## Falcon High School Building Addition Letter of Intent

### Request:

This application is to request approval of building addition to the existing Falcon High School which is located at 10255 Lambert Road building and sits on an approximate 70-acre parcel within the County of El Paso, and State of Colorado. A proposed 15,960 square foot building expansion on the north corner of the existing high school is proposed. The existing school is approximately 141,200 square feet; therefore, the proposed building expansion is approximately 11% of the current building footprint. A new concrete driveway and concrete pad will be installed on the north end of the building expansion, but no other significant modifications to the existing surrounding infrastructure is required. The overall land disturbance area for this project is approximately 2.18 acres (3.1% of overall site). The area of the proposed building expansion currently is undeveloped with native grass seed and an existing gravel driveway that drains to the south-east onto the existing parking lot and drive aisles east of the school.

CONSTRUCTION PLANS
 DETAILED GRADING & EROSION CONTROL PLAN

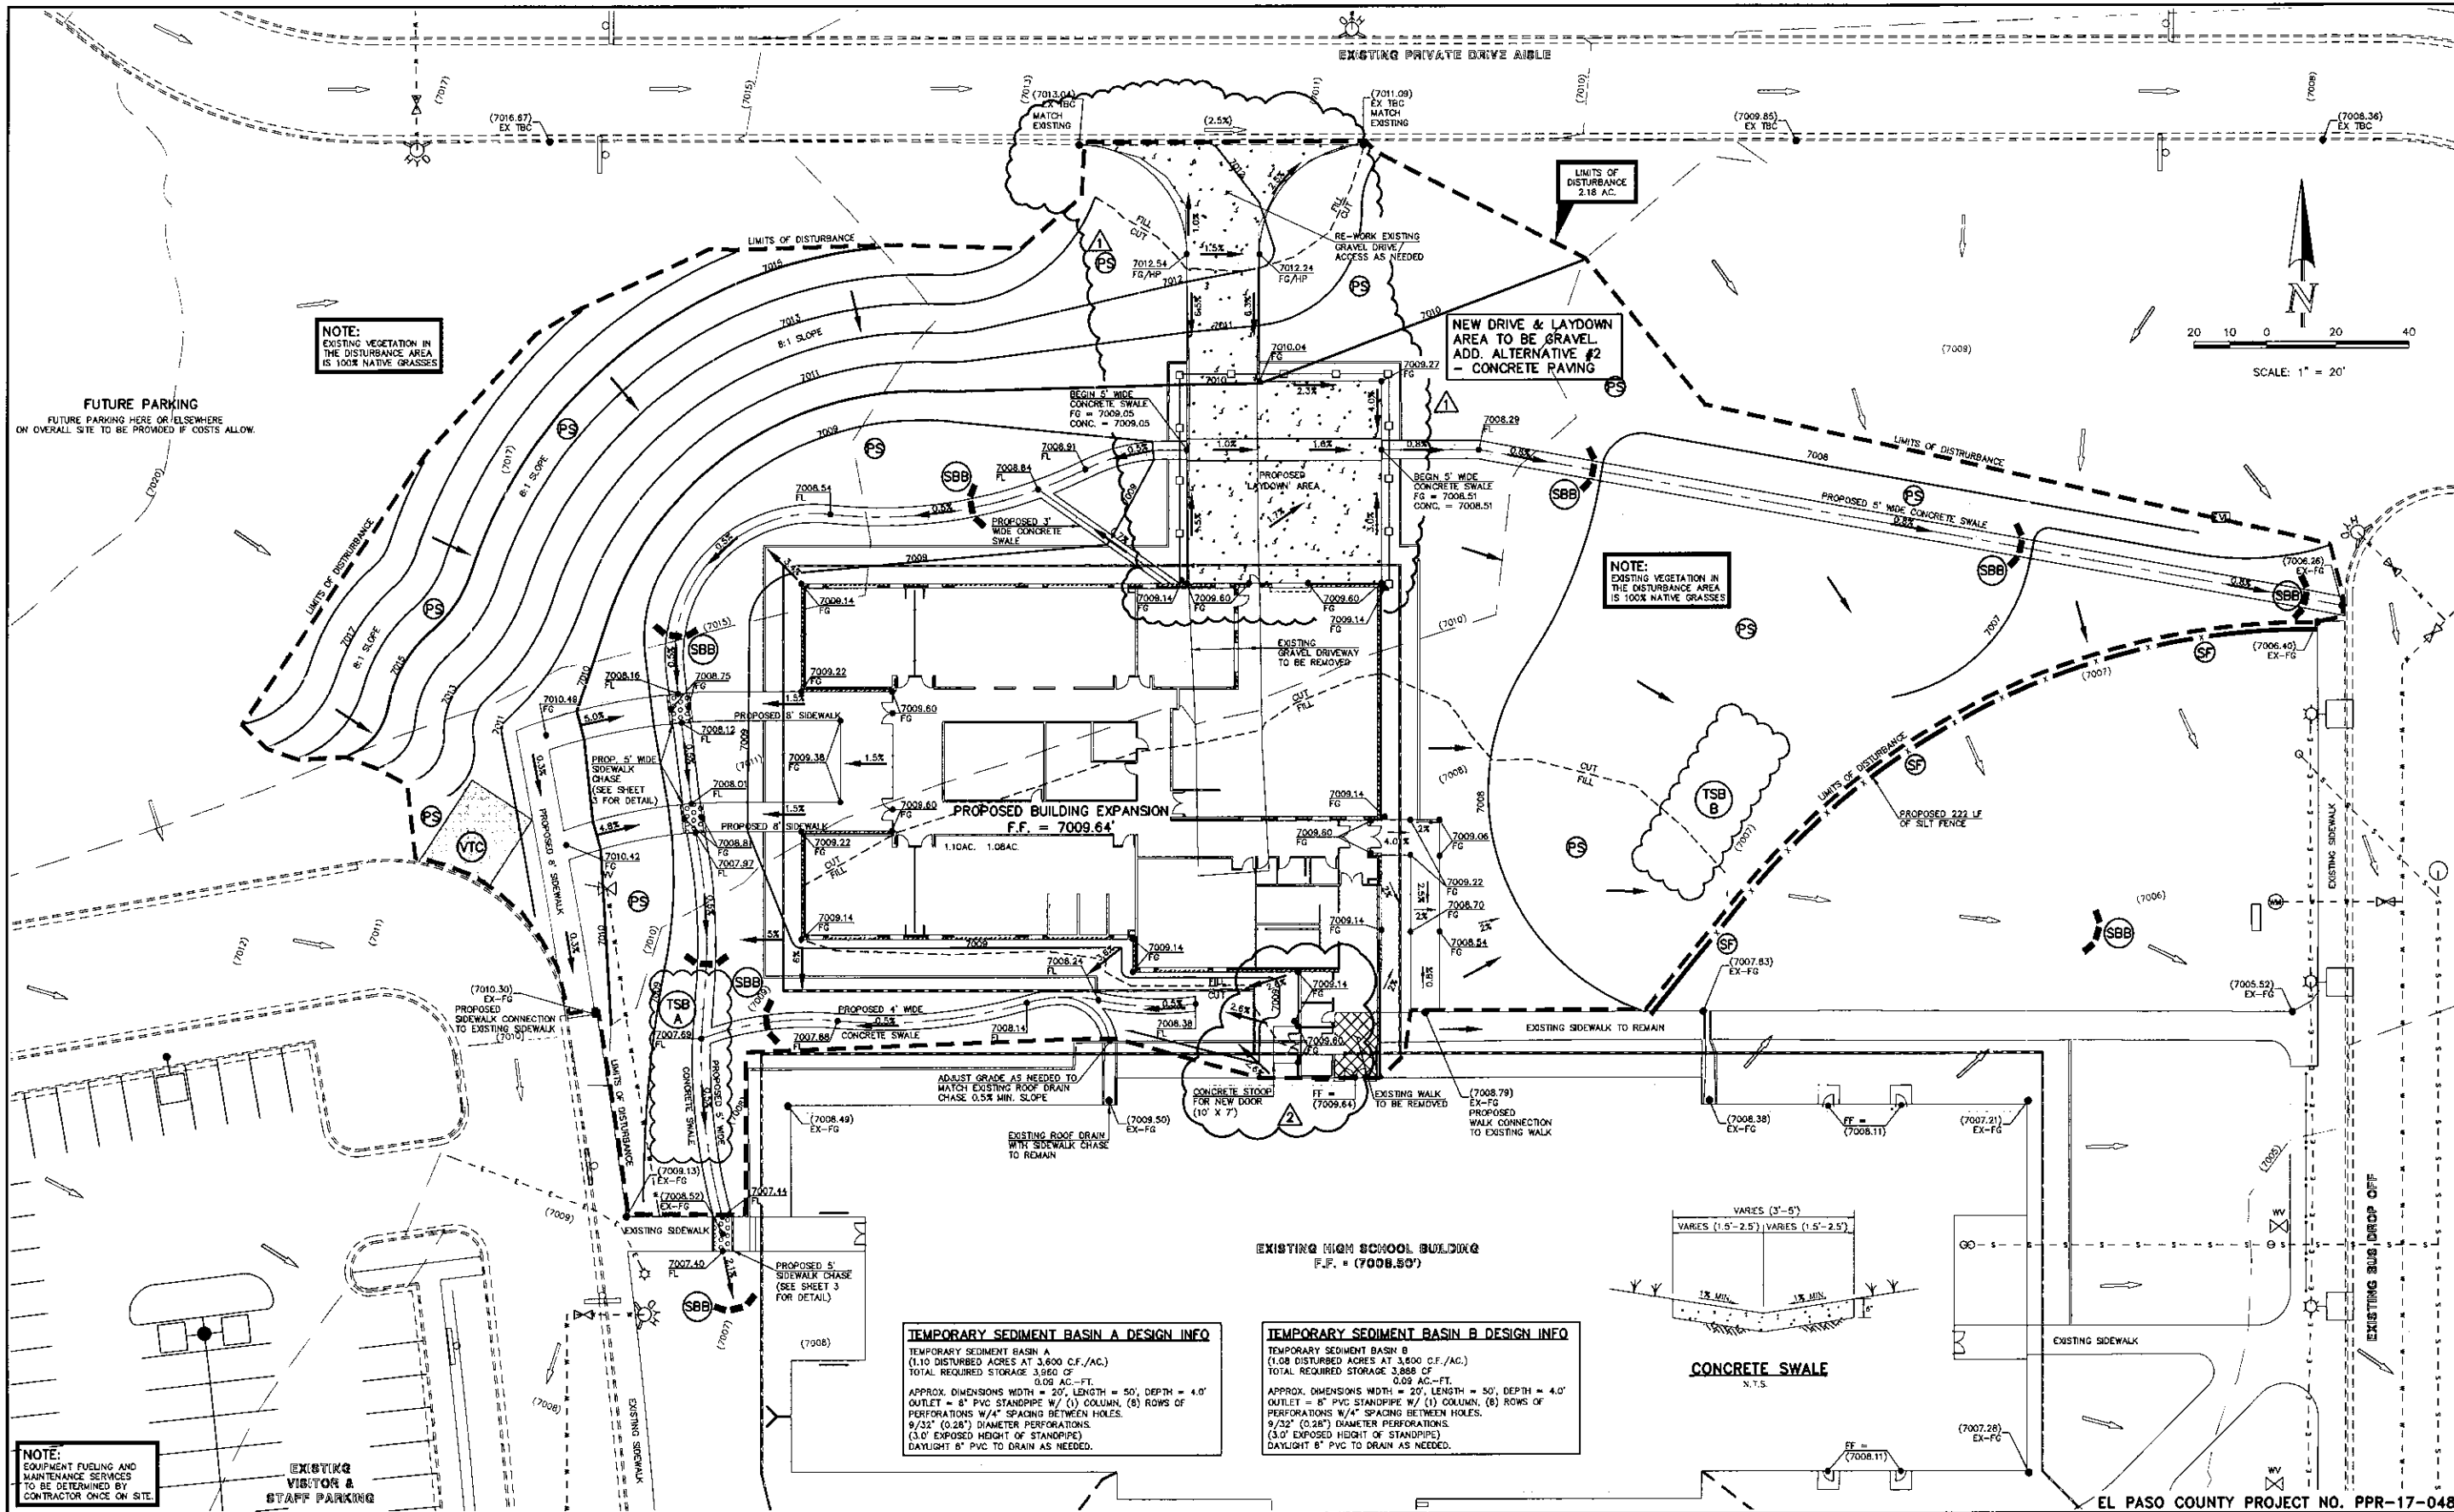
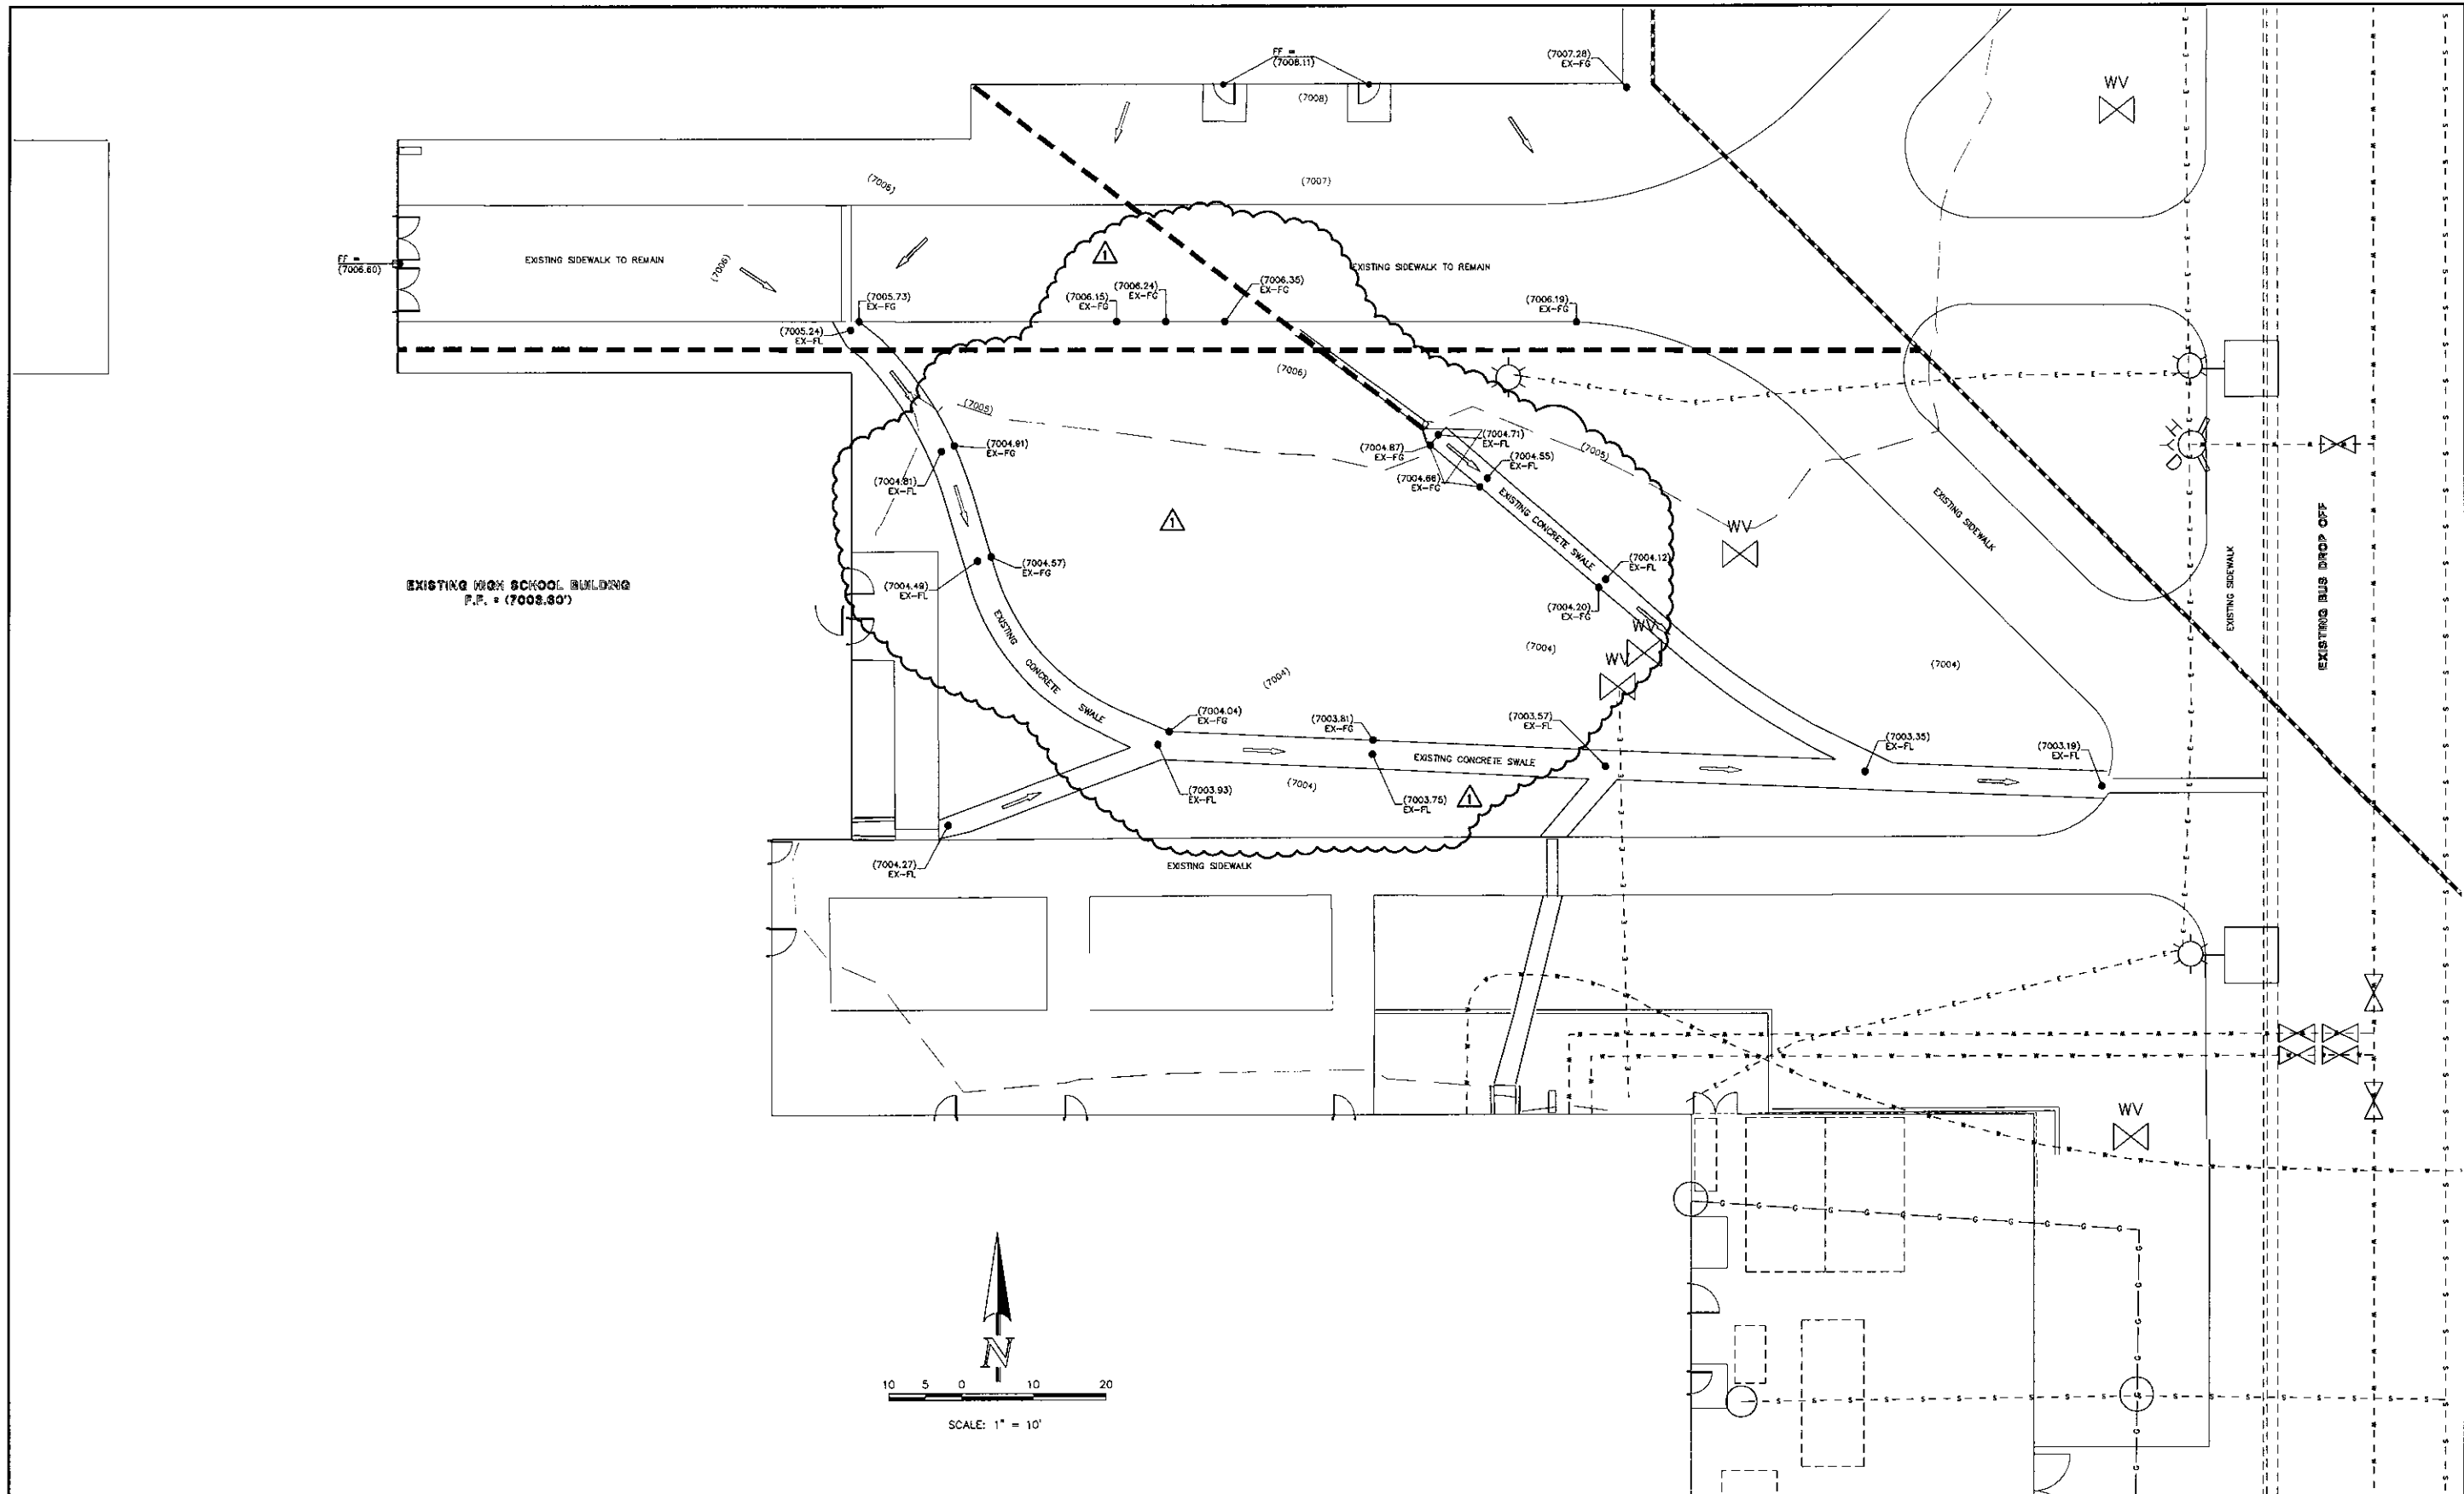
the construction documents show an add alternate that states that the driveway is gravel with an option to be concrete pavement. The LOI states that it is to be concrete. Has that decision been made? If so, please revise the construction documents, if not, please revise this letter.
